Your Ref: BE/63/17/OUT

Our Ref: PE/ARU/17/22/A

Re: The Cottage, Shripney Road, Bognor Regis, PO22 9PA

Thank you for your recent correspondence advising me of an outline planning application with some matters reserved (Access only) for 20No. houses & flats, 1No replacement dwelling (21No. units in total) with car parking, landscaping & associated infrastructure & access off Shripney Road (A29), following the demolition of the existing dwelling & outbuildings at the above location, for which you seek advice from a crime prevention viewpoint.

Fig 2. Proposed Indicative Site Layout Plan

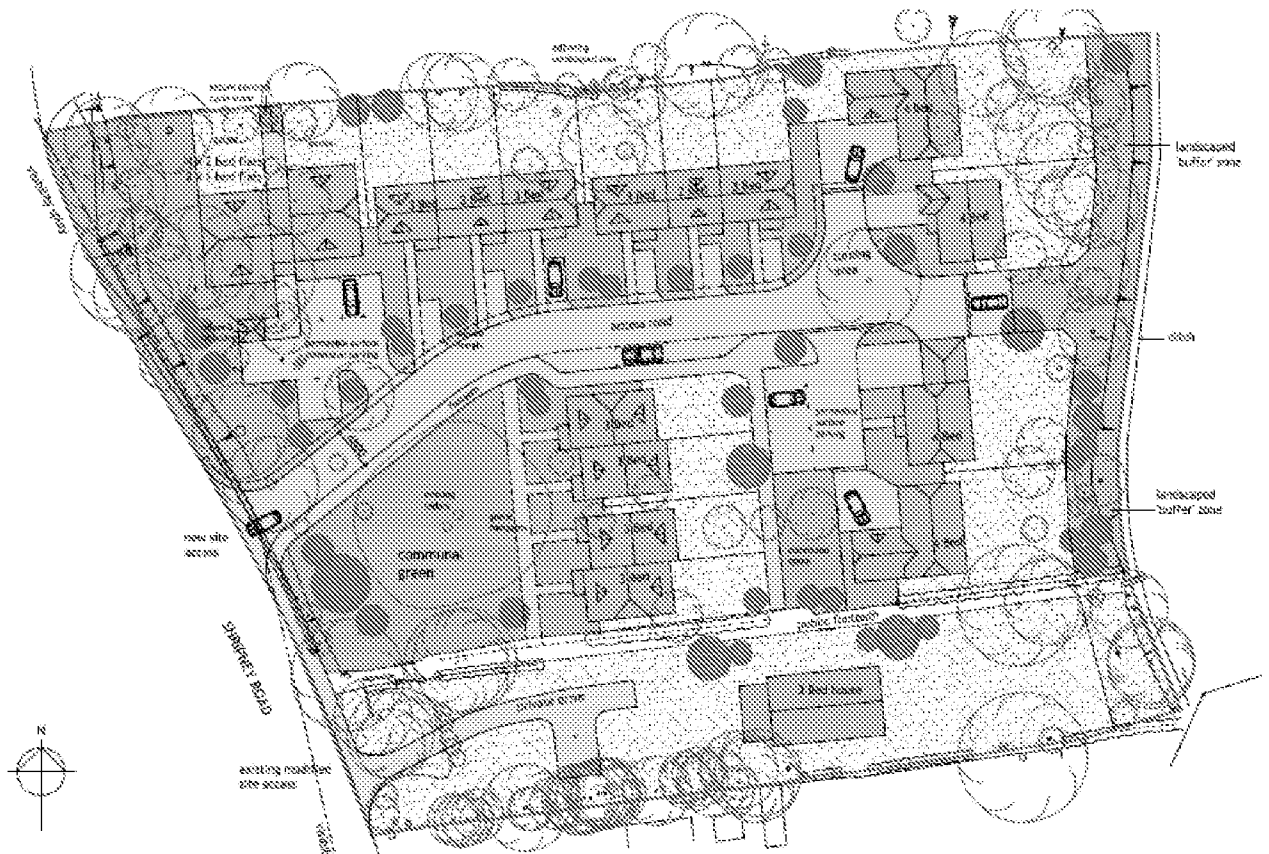
In the main I do not have any concerns with the proposed development's design and layout, however there a couple of concerns I would like to raise concerning the public footpath running through the development.

Secured by Design discourages the siting of public footpaths to the rear of dwellings, to provide access to gardens, rear yards as these have been proven to generate crime. This path provide unobserved access to the rear of 6 dwellings and a parking court. Where such a path is unavoidable, it should be wide, adequately lit, as straight as possible, devoid of potential hiding places and overlooked by surrounding dwellings.

I recommend that presence of lockable gates and fencing to the sides of the flats will remove any easy access to the vulnerable ground floor windows and the cycle store. Consideration could be given to the relocation of the cycle store from their present location to the front of the block adjacent to the refuse store. This would enable the store to have natural surveillance over it as well as observation from active rooms from within the flats. It will make accessing the cycles easier for the residents by being at the front of the block.

Finally, lighting throughout the development including the parking and communal areas would be very beneficial and if implemented should conform to the recommendations within BS5489:1-2013.
